# City of Albuquerque Stormwater Construction Site Inspection Report

ESC File No.	K09E050	Project Name:	Bluesky Distributing Tract 9B		
NPDES Id. No.	NMR10051D	Location:	Bluewater Rd and Daytona Rd		
7/12/2023	Owner		Contractor		
Operator	Aspen and Autumn LLC				
Contact name & title	Robert Poole				
e-mail	blueskyrobert@yahoo.com				
Contact Phone #	263-4047				
COA Inspector	Chancellor English		Start/End Time:	10am	
Construction Phase:	infrastructure				
Type of Inspection:	Regular	Storm Event	Post Storm Event >0.25"	311/Complaint	Follow Up
Weather at time of inspection?	Clear		Temperature: ~	95	
Estimated date of last storm 0.25" or greater	5/22/2023

SEDIMENTATION/SILT FENCE WITH WIRE SUPPORT

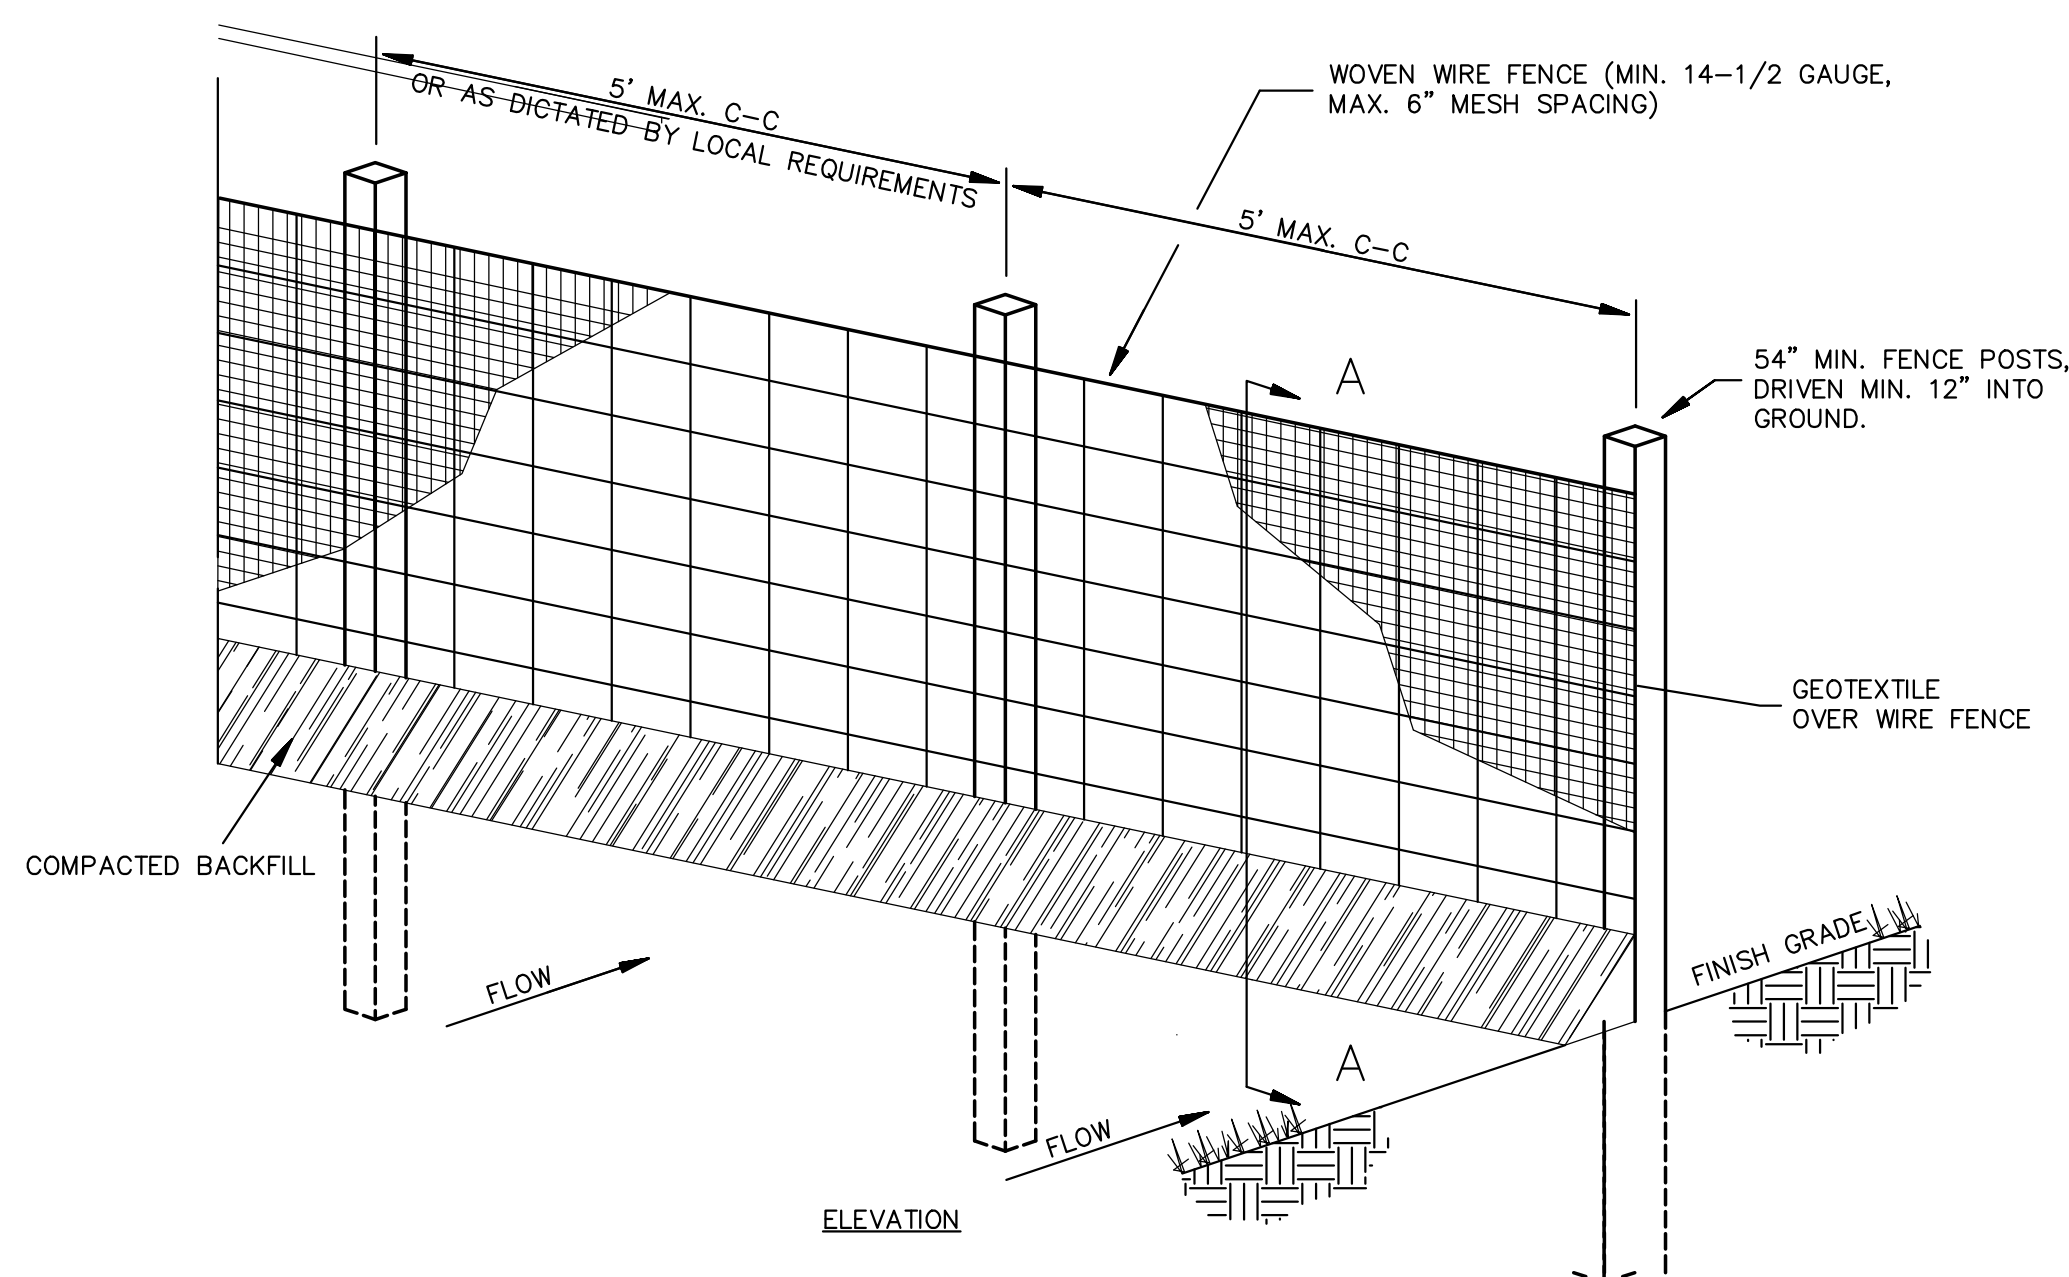
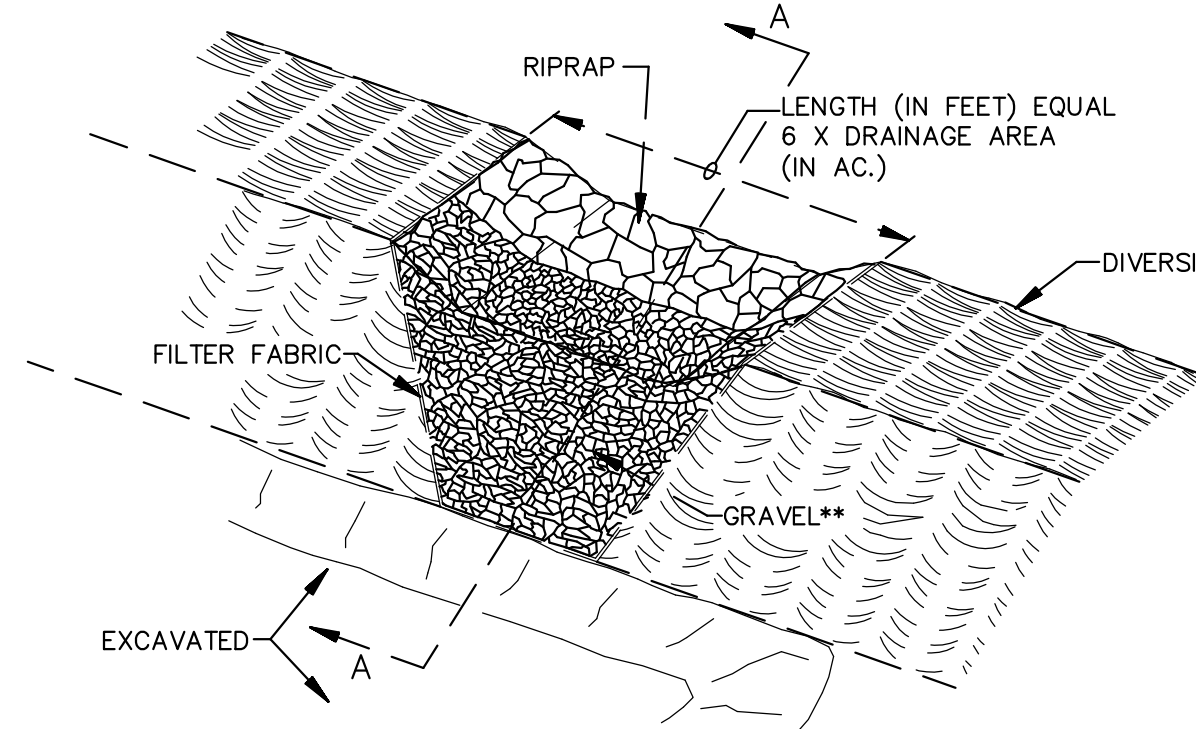
2	BMPs were damaged or collapsed. Multiple sections of the perimeter silt fence on the west and south edges of the properties need maintenance and/or repair. Required mitigation: You must ensure all stormwater controls are maintained and remain in effective operating condition during permit coverage and are protected from activities that would reduce their effectiveness per CGP 2.1.4.			
3	There is sediment discharge originating at a dirt ramp that has been recently installed on the southwestern corner of the Aspen and Autumn, LLC property that exits onto Bluewater Road. The track-out has caused a significant sediment trail along the curb of said road. Required mitigation: You must restrict vehicle use to properly designated exit points, use appropriate stabilization techniques at all points that exit onto paved roads, implement additional track-out controls to ensure that sediment removal occurs prior to vehicle exit, and remove, by proper measures, the deposited sediment by the end of the same business day, or next business day if occurring during on a non-business day per CGP 2.2.4.
